**Final Report - Corrections Required**  
**Application No. ANEX-23-0014**

**Description :** A request by Norris Ranch Joint Venture, LLC, for annexation of 19.605 acres into the City of Colorado Springs. The annexation is a part of the overall Karman Line Land Use Plan, which is being submitted concurrently. The Land Use Plan proposes a maximum of 6,500 dwelling units, approximately 45 acres of light industrial, 105 acres of commercial/retail, 100 acres of mixed-use development, and 570 acres of park/open space.

**Subject: Karman Line Land Use Plan AKA Norris Ranch, MAPN-23-0002**  
**Colorado Springs, El Paso County, Colorado; CGS Unique No. EP-23-0068**

KARMAN LINE LAND USE PLAN
 SLOPE ANALYSIS

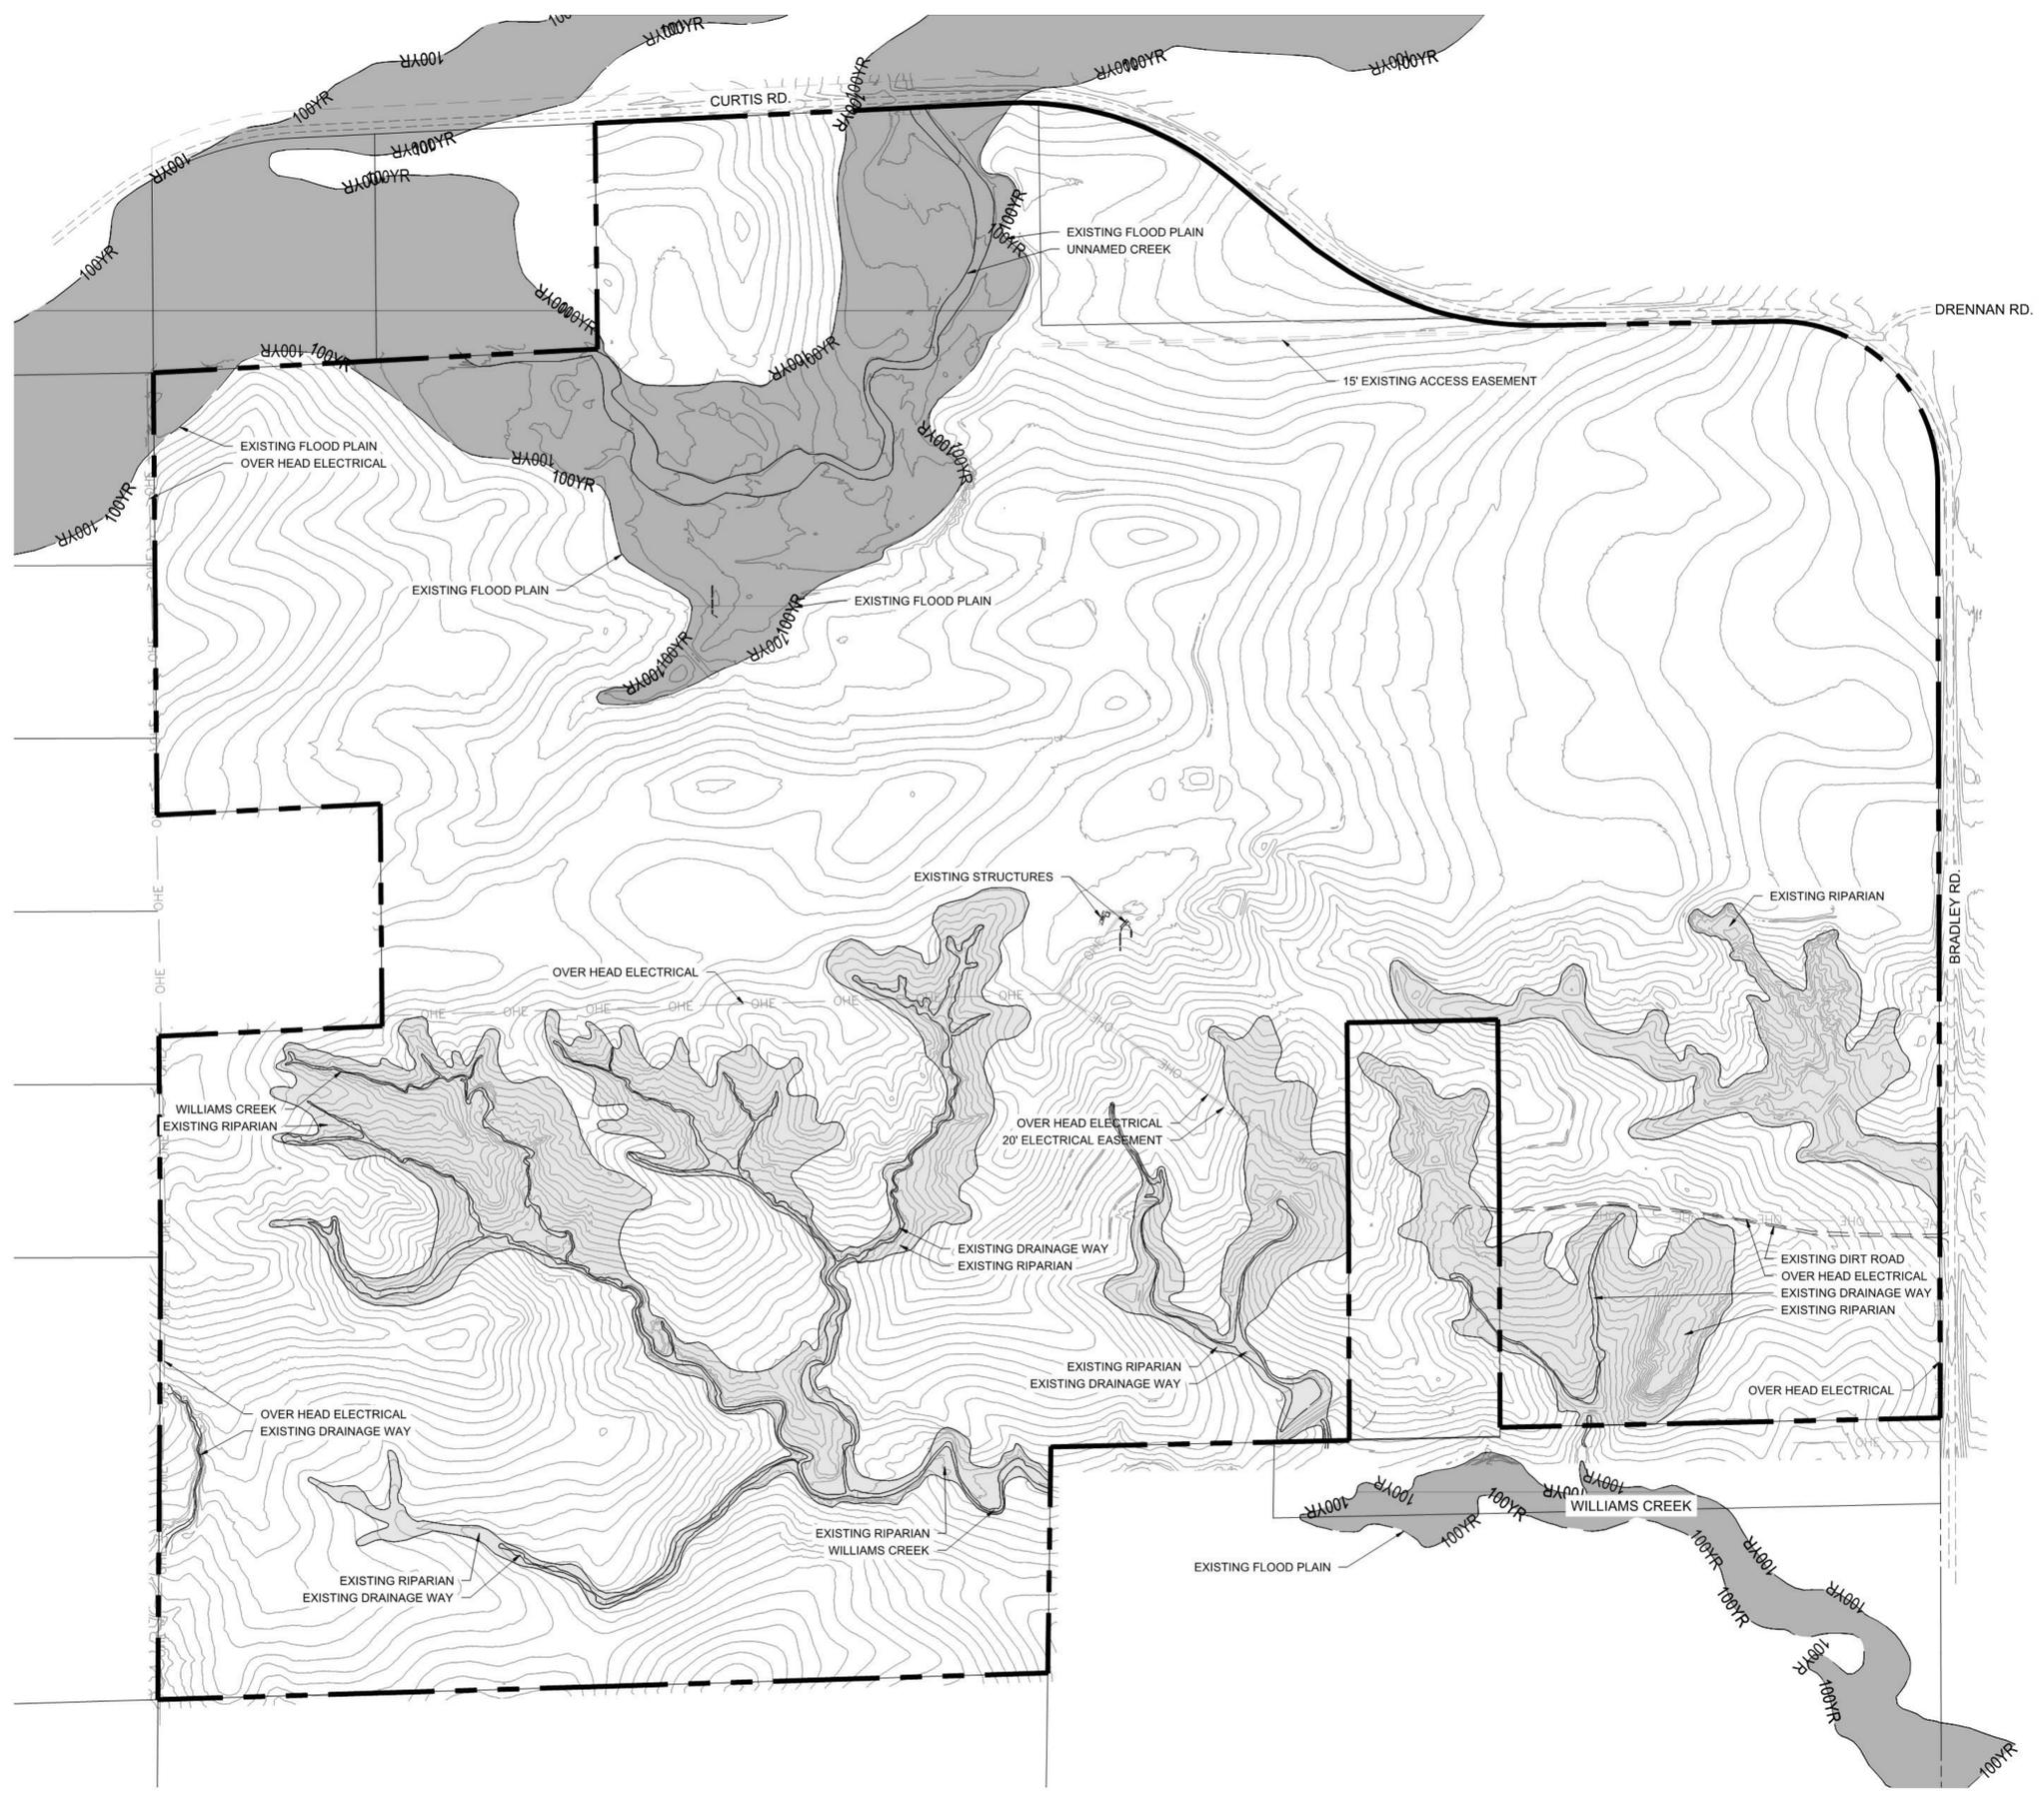
Potentially unstable slope areas. CGS concurs with Entech's recommendation (p. 11), "Building should be avoided on the potentially unstable slopes unless they are stabilized," and with their recommendation of "A

minimum setback of 30 feet from the crest of these slopes.” CGS recommends that site-specific and detailed quantitative slope stability analysis be required to verify this setback as development plans progress.
